Development Control  
Ribbles Valley Borough Council

**Re:** Planning Application 18/0435

**Address: 32 Hall Street Clitheroe BB7 1HJ**

**Description: Demolition of existing property and associated outbuildings and erection of six three-bedroomed town houses.**

PROPOSED SITE PLAN

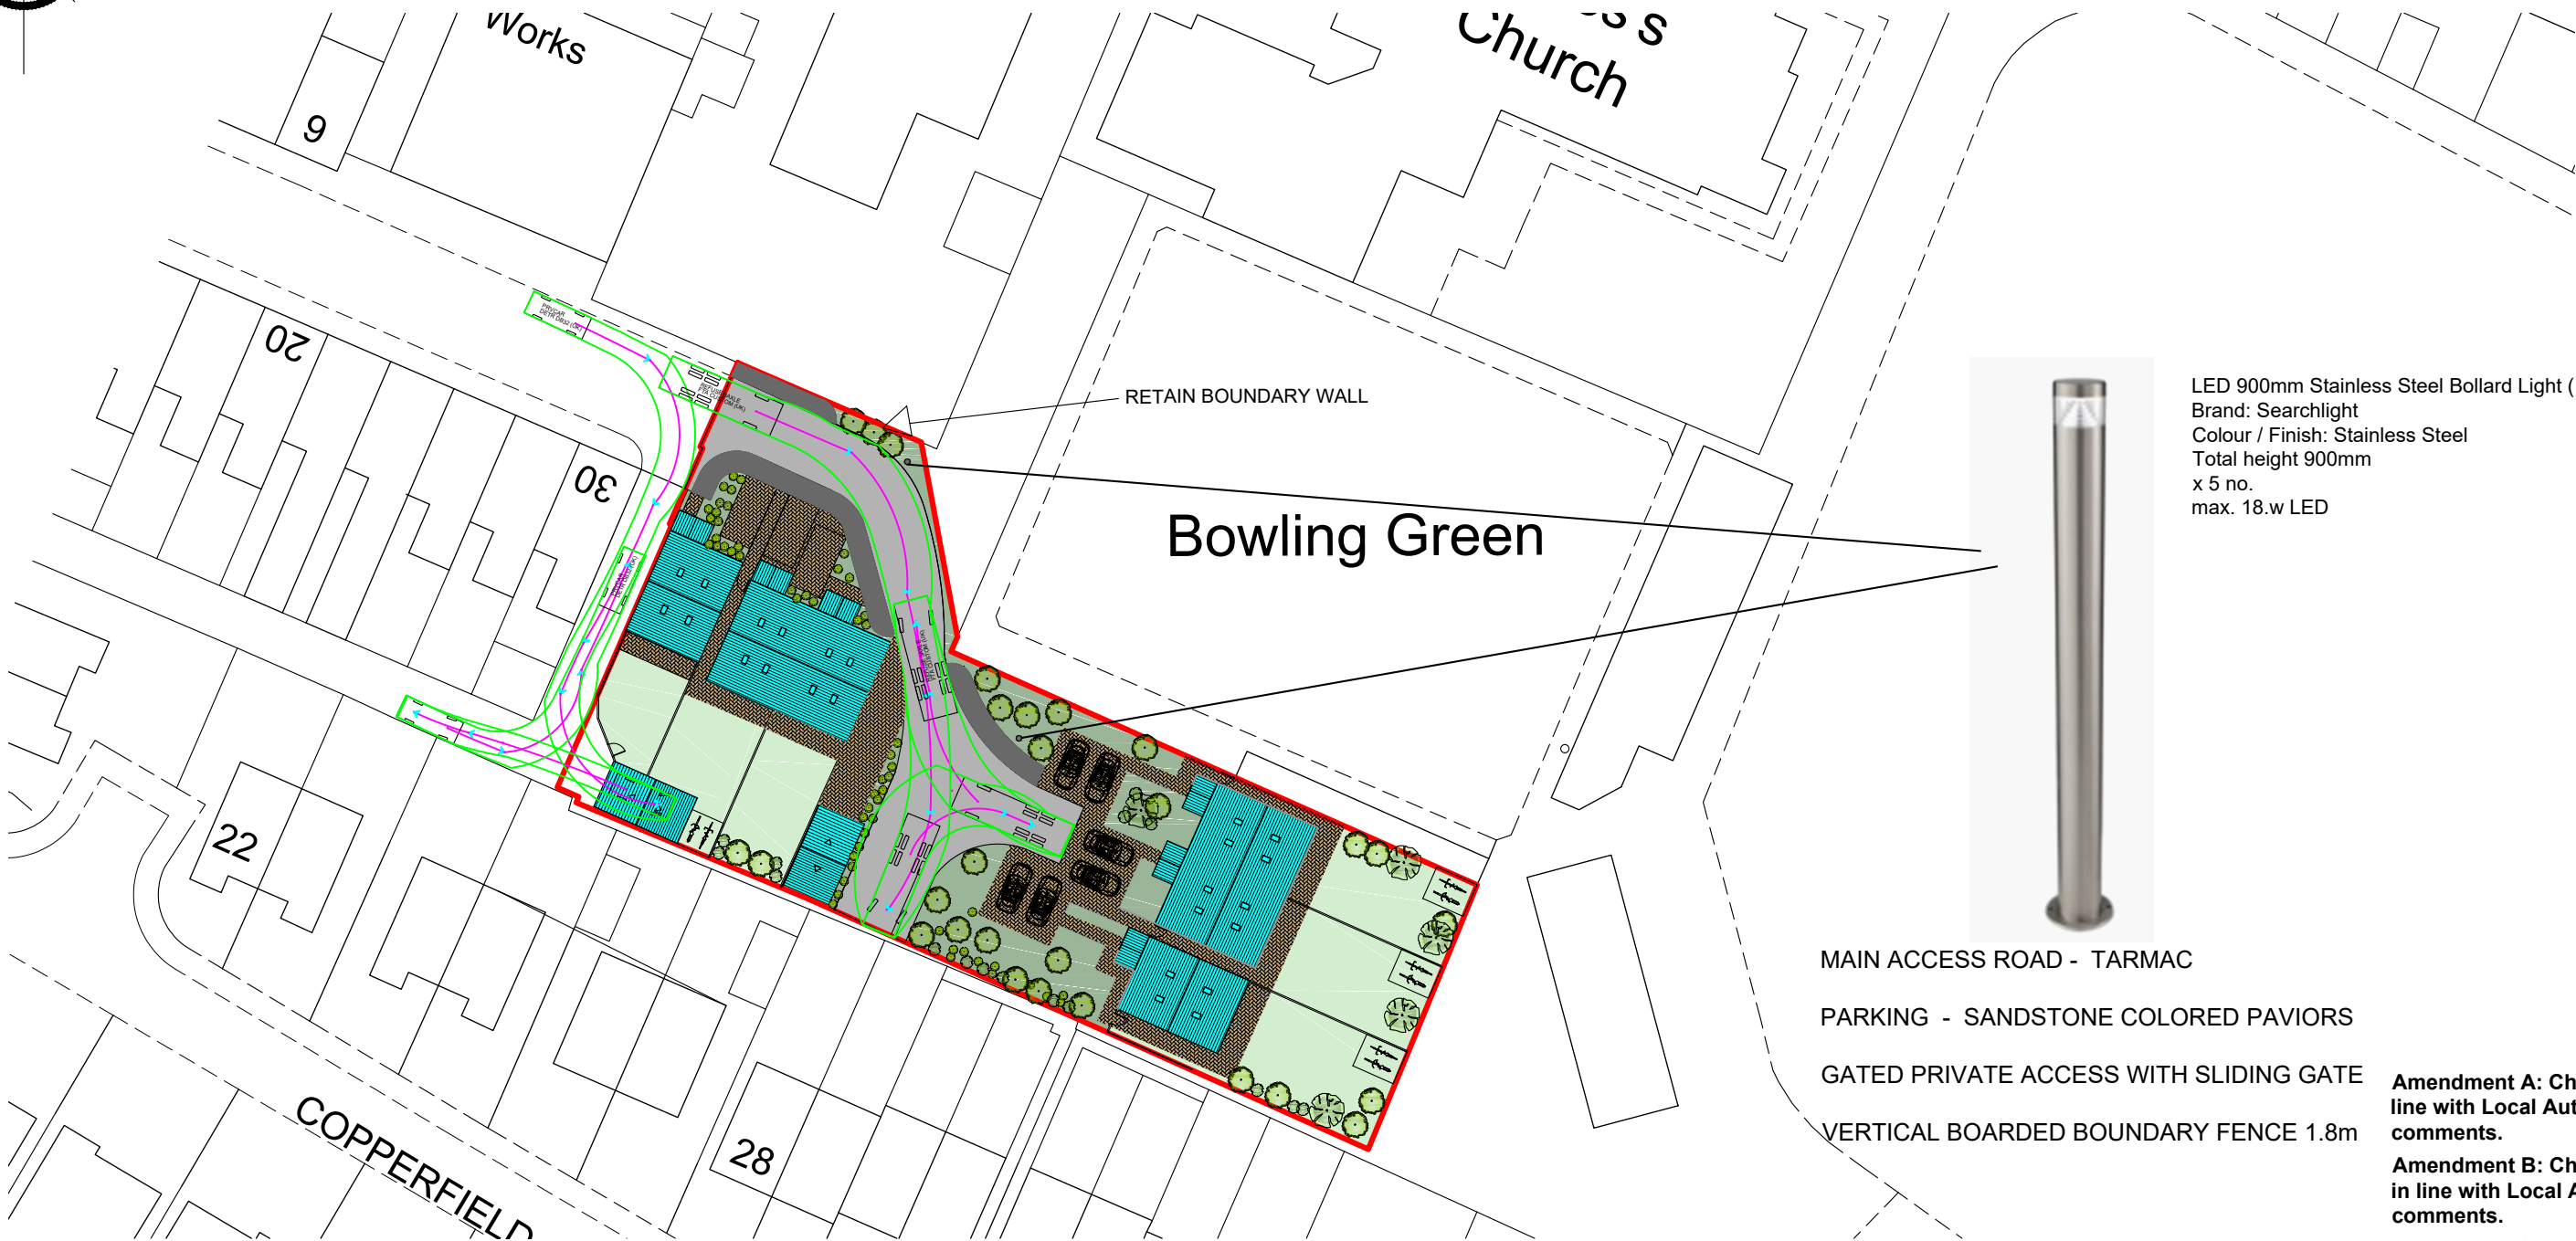
- The access from Hall Street, this should be widened to allow 2 cars to pass through the opened gate and beyond for a distance of at least two car park space lengths (9.6m).

- There appears to have been no provision made for pedestrians or cyclists to access the development without opening the main gate across the carriageway

- Nor does there appear to be any provision for pedestrians within the development.
- There is no provision for access to the rear of the plot at the gable of 30 Hall Street without passing through the dwelling.

- Nor has there been any indication regarding the provision of any street lighting or surface water drainage.
- A swept path analysis should be undertaken to ensure that a refuse collection vehicle can enter and exit the development in a forward gear.

- With the exception of the plot with the garage, suitable covered and secure storage should be provided for at least 2 cycles per dwelling.
